2023/0380

Demolition of existing bungalows and erection of a pair of semi-detached bungalows

The Bungalow, 120B St. George's Road, Barnsley, S70 1HA

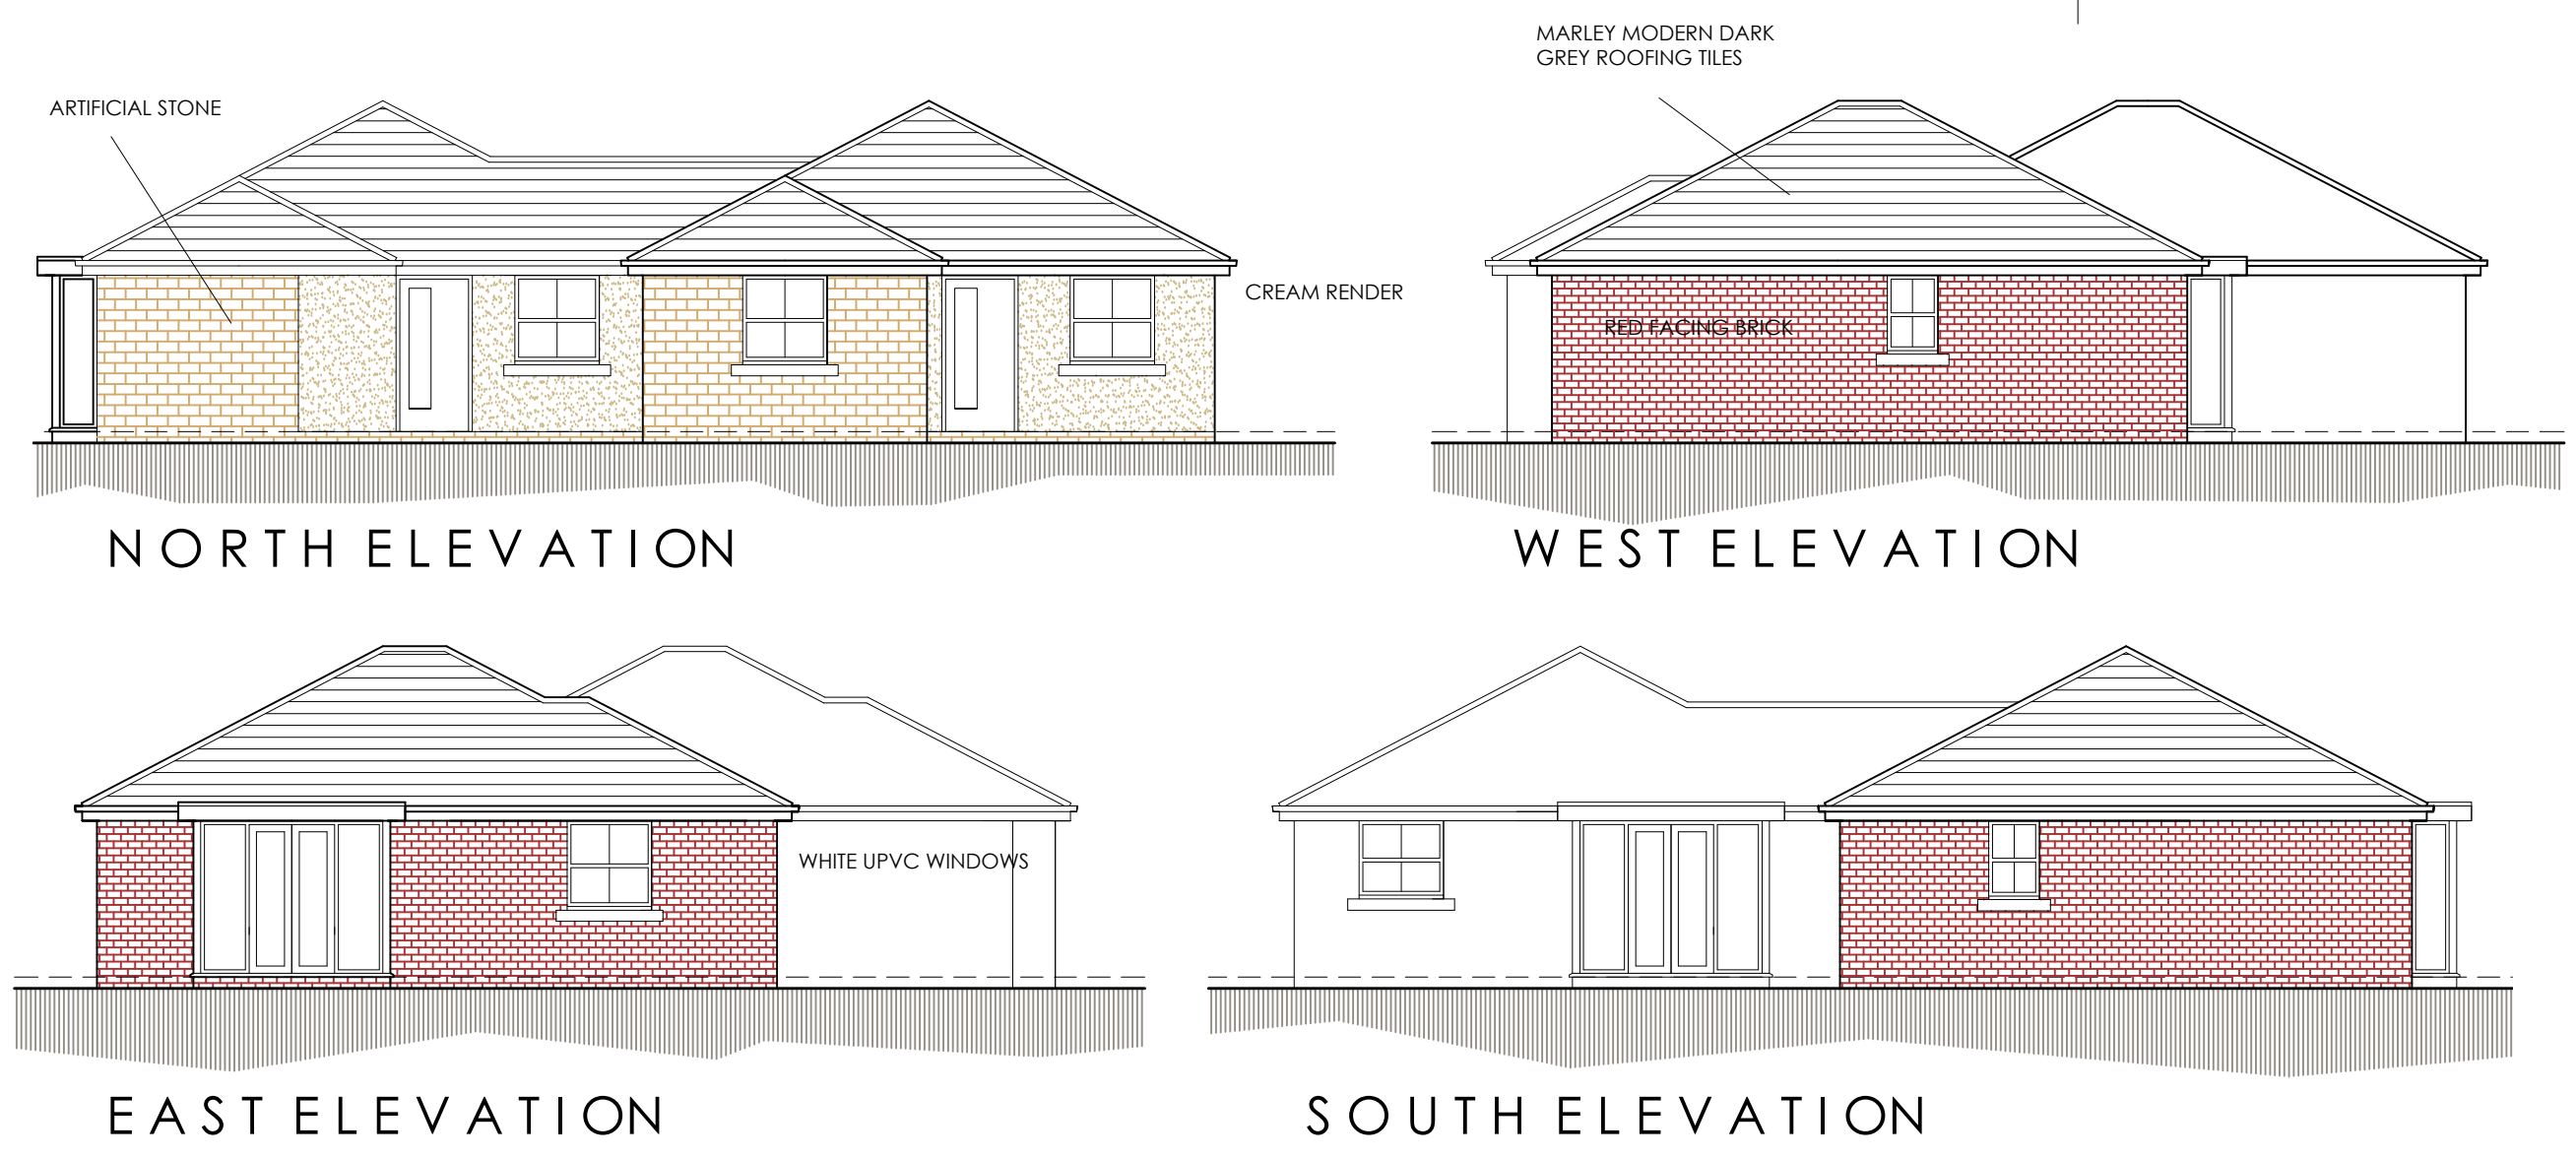
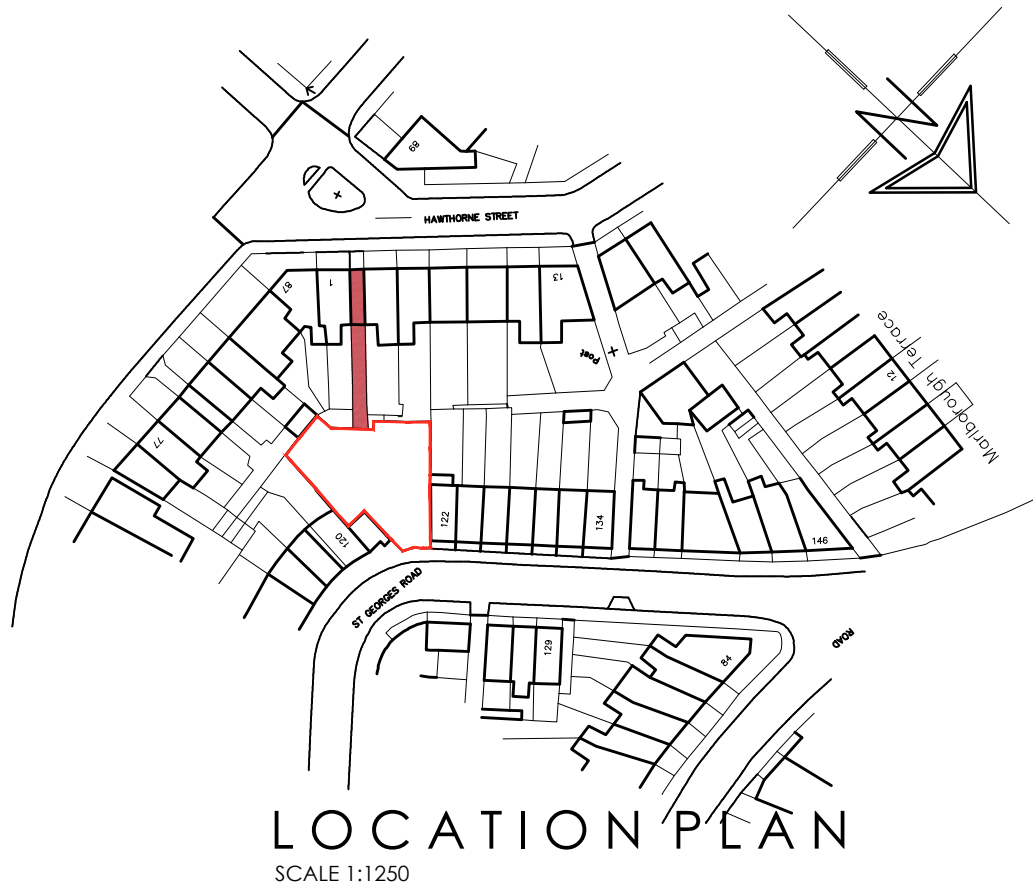
The site is a tight infill plot which is nestled in between several residential properties. There were initially concerns raised that the development would be too close to existing neighbours which the amended plans (Final Revision – Rev. C) sought to alleviate. The proposed layout of the development showed that the separation distance for plot 2 met the minimum criteria and plot 1 was equal to the existing bungalow (showed as an outline on the proposed site plan).

However, the site is tight, completely enclosed on all sides by existing residential properties with limited outlook from both properties, particularly the rear elevation of plot 2 which faces onto the rear boundary brick wall at a distance of 5m, and just meets the minimum external spacing standard for amenity space (51.5sqm). Additionally, there is limited space within the site for soft landscaping with a very small area to the immediate front of the sole window serving the proposed bedrooms, which creates a conflict in the sense that there will be pressure to prune the soft landscaping. Also, the bedroom for plot 2 would be in close proximity to the parking area serving both plots and the pedestrian path serving plot 1. Likewise, the outlook from both bedroom windows is limited in that they both face onto the side elevations of neighbouring properties. The development should be assessed in that it provides limited living accommodation (1-bed properties) with very little expansion potential for a larger number of occupants.

Whilst the amended plans have increased the separation distance to neighbouring properties and the internal layout has slightly eased the concerns with outlook from plot 2, the development is still considered to result in poor-quality living accommodation for the future residents of both plots and would be much better coming forward as a proposal for a single replacement dwelling instead.

However, the application site is a very tight infill plot nestled between two established rows of terraced housing. Equally, to the rear is a separate terrace row which completely encloses the site in all directions. The site faces North-West onto St. Georges Road with a very narrow frontage (c. 6.5m in width) and generally, the site is considered to not be of a sufficient size to appropriately accommodate two dwellings. The presence of two semi-detached properties on the site will appear squeezed onto the plot, with two closely linked bungalows being at odds with the existing character of the area which is predominantly two

storey terraced properties. The SPD states that the siting of the infill dwellings should reflect the building line of the dwellings on the same side of the street. It is appreciated that two storey terraces are not achievable in this location. However, the layout of the proposed development as it currently stands is considered to appear at odds with the surrounding street scene with the existing bungalow being the sole example of such property type within the area and is largely screened from view given the presence of a high brick wall on St Georges Road and screening from existing neighbouring properties. As such, the existing bungalow has a neutral impact on the street scene.

Developments should seek to raise the design standard of the area, with the proposed dwellings squeezed onto a plot which is inherently tight. As a result, the development looks (both on a plan and from the street scene) shoehorned into the plot and at odds with the prevailing character of the streetscene. To accentuate this impact, there is minimal space for soft landscaping within the plot, with the area to the immediate front of the dwellings only being large enough to predominantly accommodate hard surfacing for parking. There is a small area of soft landscaping positioned immediately to the front of the two-bedroom windows on site. The soft landscaping doesn't meet the guidance from Building for Life of a 50:50 hard/soft landscaping balance at the front of dwellings, as referenced in the SPD (section 11.3). The positioning of which would potentially be unfeasible in the long term given that it is in very close proximity to the bedroom windows and would be a maintenance burden for future residents. In all likelihood, the area of soft landscaping would not be suitably maintained for the long term.

Both plots would appear cramped and hemmed in, particularly plot 1 which due to the staggered plot arrangement would see it pushed back deep into site in more of a backland location that would be largely hidden behind No.120 St Georges Road in very close proximity to the rear boundary of the site.

The small size of the plot also generates issues in terms of residential amenity for future residents with lack of privacy and outlook from the bedroom windows of both plots, and the rear facing windows of plot 2. Both bedrooms partially face onto the side elevations of neighbouring buildings, and the rear facing windows of plot 1 face onto the rear boundary treatment at a close distance. Also, the bedroom for plot 2 would be in close proximity to the parking area serving both plots and the pedestrian path serving plot 1, with the end result being a cramped form of development in a poor quality backland location. Further, plot 2 has external amenity space which just meets the criteria for external amenity space set out in the SPD for Design of Housing Development, with very little space for future expansion. All of these things considered the proposed development is considered to be contrary to Local Plan policy GD1 and the Council's SPD for Design of Housing Development in that it will not result in high quality residential development to meet the future needs of the borough.
